## Jacfin Pty Limited – Part 3A Project Application (No. 07\_0153)

### Response to Submissions

JOINS LP-03

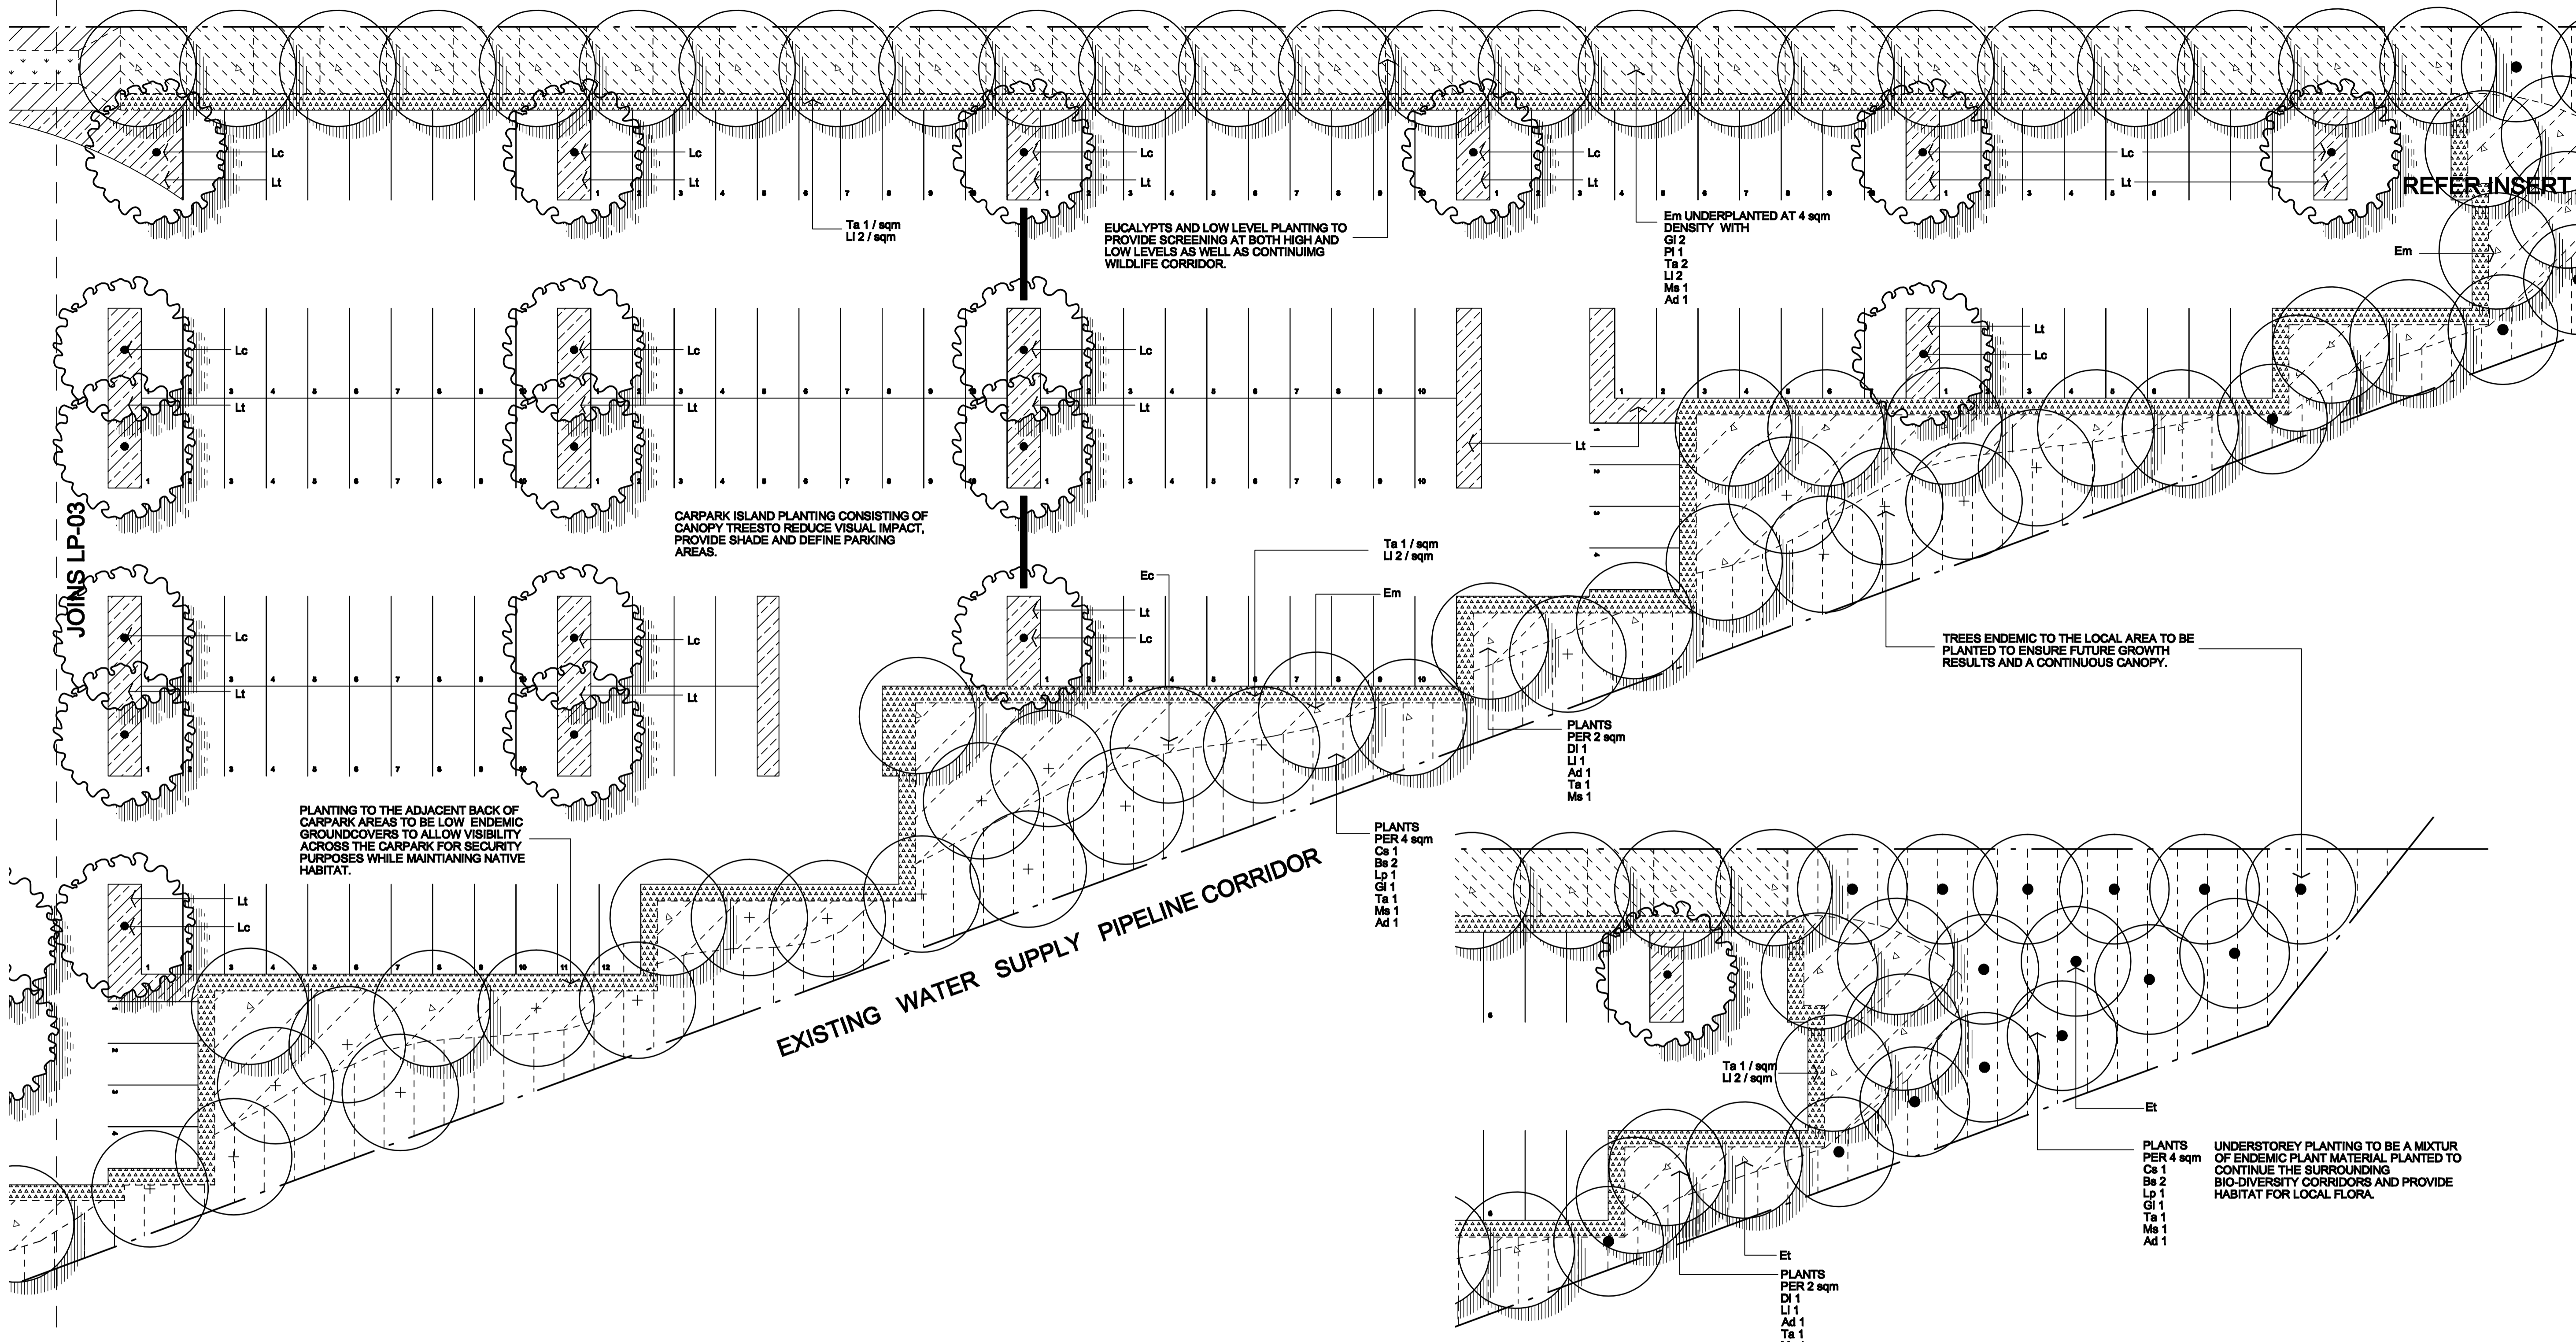
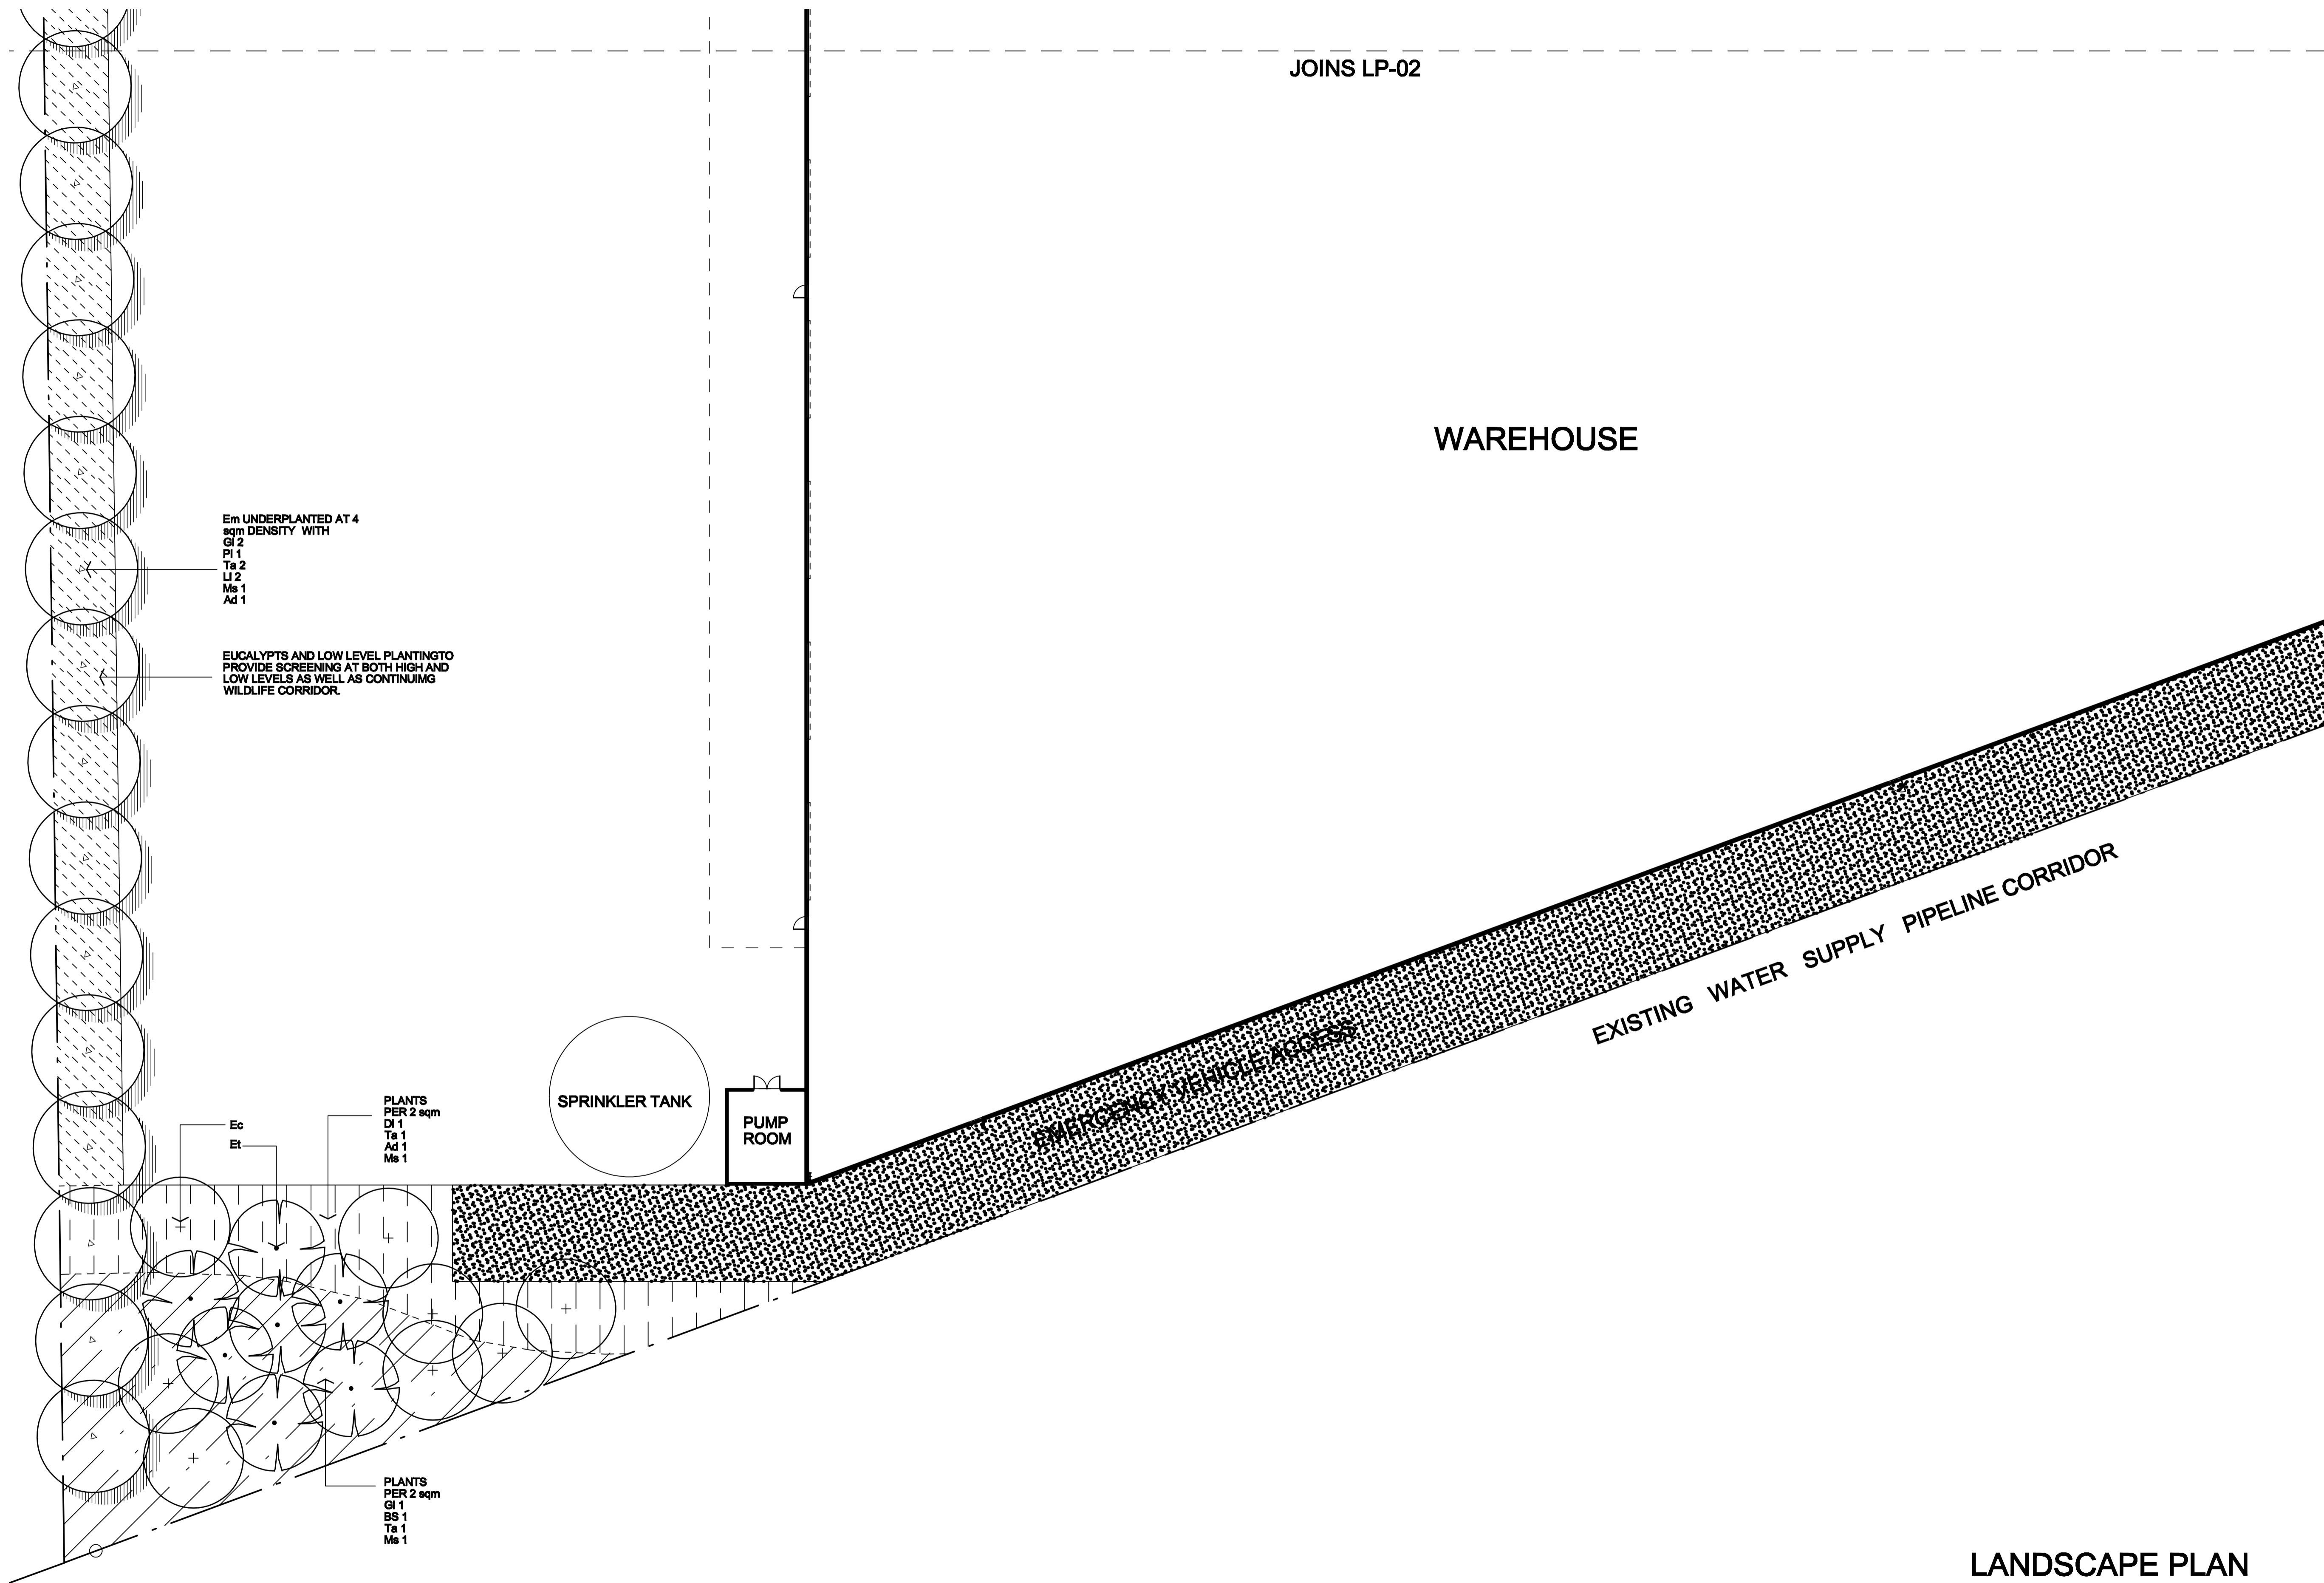
Issue	Response	Addressed in EA
<b>Ivan Jeray (private individual)</b>		
<p>(a) Non-local native plants (including hybrid and cultivar species) proposed in landscaping plans are not supported.</p>	<p>(a) The Landscape Plan for the site was prepared in accordance with the <i>Flora &amp; Fauna Report</i> recommendations, which were based <i>inter alia</i> on the Penrith City Council DCP (2006) and the NPWS <i>Technical Report on the Native Vegetation of the Cumberland Plain, Western Sydney</i> (2000).</p> <p>In this regard, the proposed landscaping for the site is considered suitable and compatible with the locality. It is also noted that neither Penrith Council nor the DECC (which absorbed the former NPWS) have objected to the proposed landscaping.</p> <p>Introduced and non-local native plants are not regarded as problematic in an industrial landscape. In the case of cultivars, the final Landscape Plan will be refined to ensure that cultivars used do not compromise any indigenous plants.</p>	<b>Section 6.4, 6.10, Appendix D.</b>
